COLORADO GEOLOGICAL SURVEY

In response to your request and in accordance with Senate Bill 35 (1972), CGS has performed a technical review concerning geologic hazards for the above-mentioned proposed development. The site consists of approximately 39.2 acres and is being platted to include 5 residential lots ranging from 6.8 – 7.6 acres in size. The lots will use individual well and septic systems. Included in the review package were: the submittal letter (3/25/10) by LDC, Inc., final plat (1/9/09) by LDC, Inc., and geology and soils study (11/14/08) by Kumar & Assoc. *No drainage report or grading plans were included for review by CGS.*

FINAL PLAT
MOUNTAIN'S EDGE

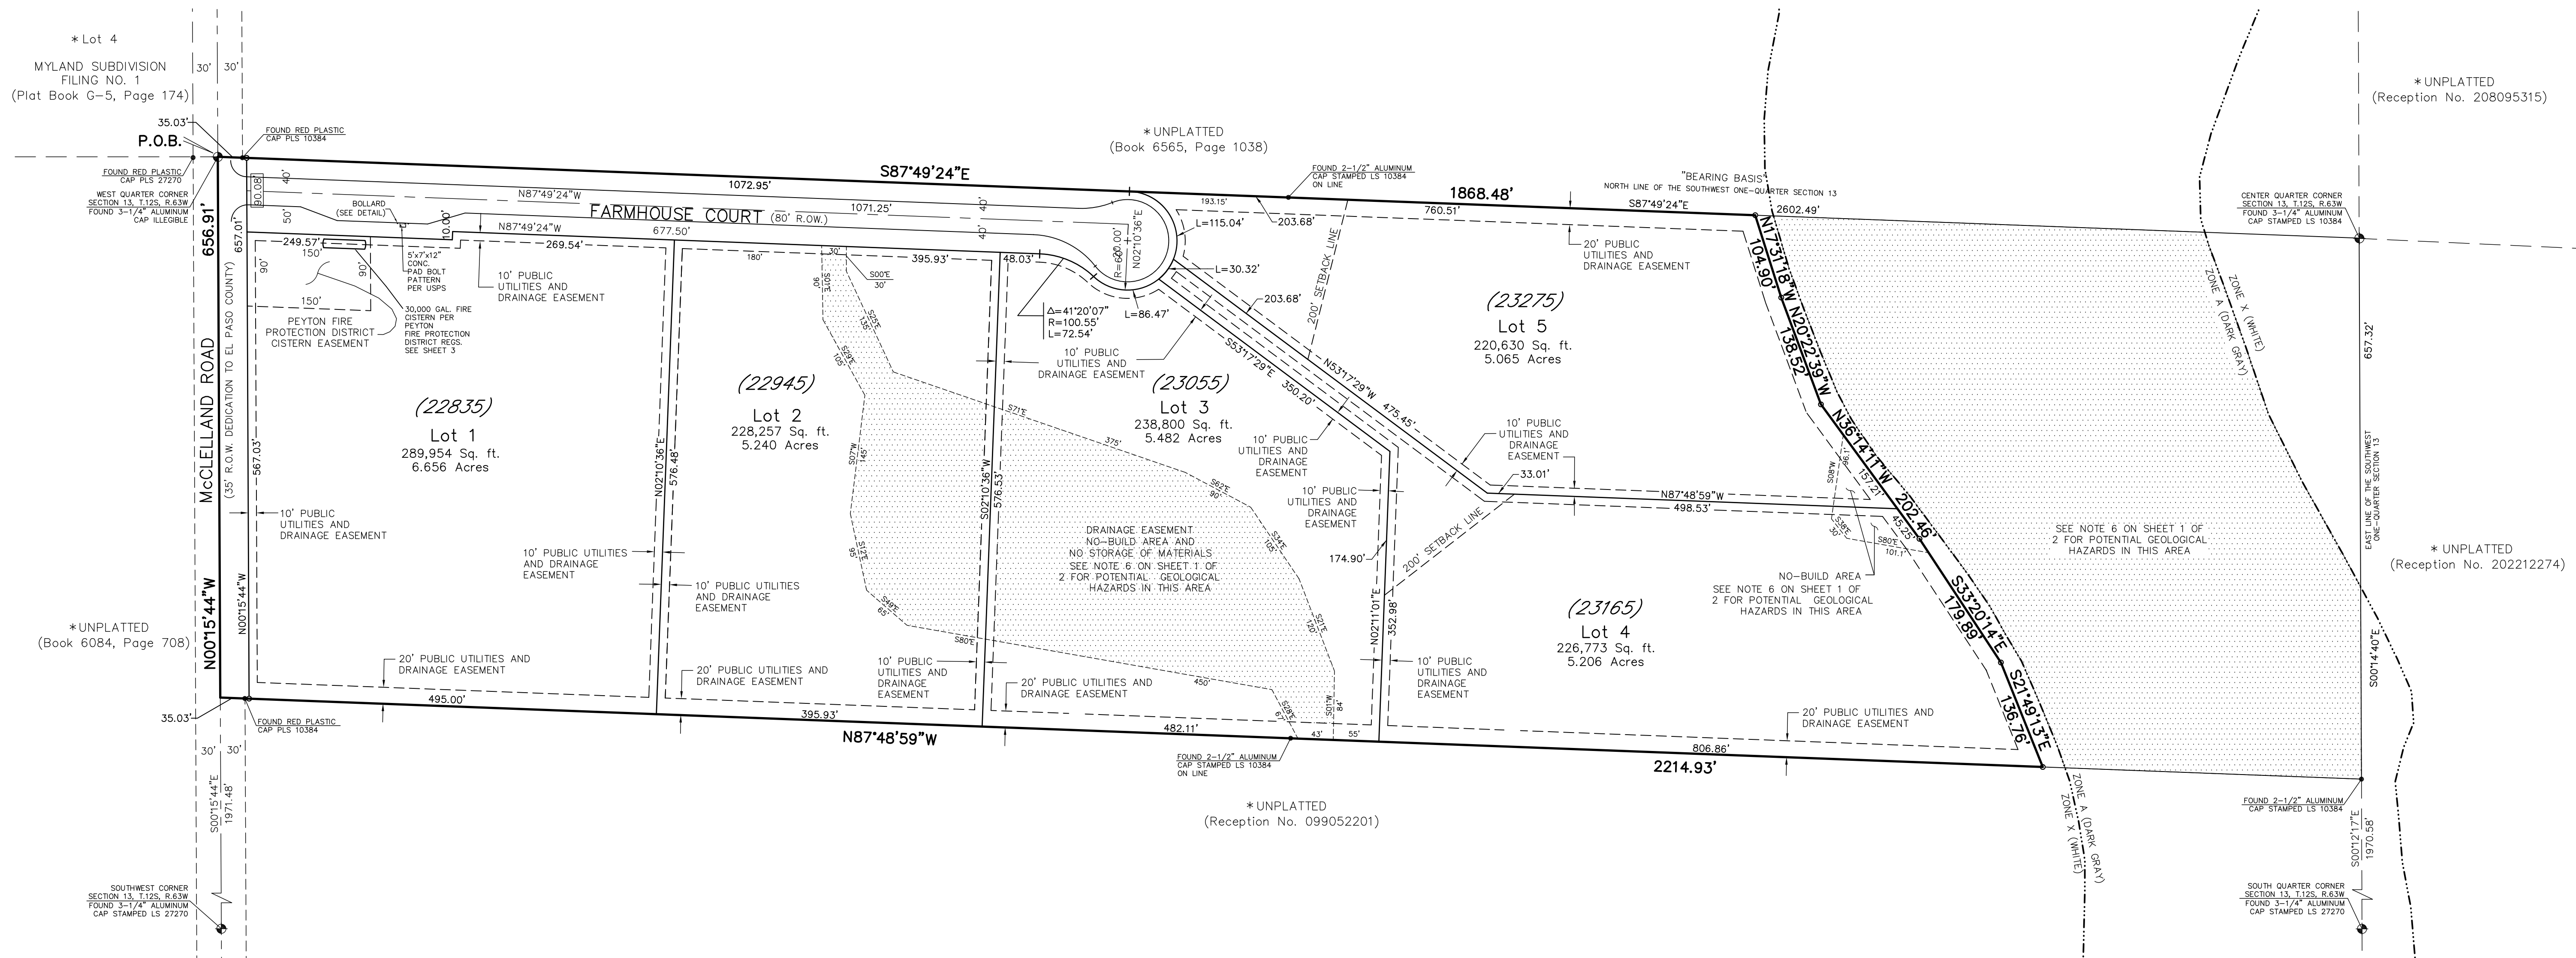
1. Development and grading should not be permitted within the 100-year flood plain boundaries. It may be prudent to develop a setback from the FEMA flood plain, since it was developed on a 1:24000 scale and not a site-specific scale. FEMA maps should not be considered accurate at a site plan scale.
2. Areas of old fill and debris should be removed prior to development.
3. Kumar recommends using a 100-foot setback from the creek for erosion protection if the drainage banks are not reinforced. This should be indicated on the plat.
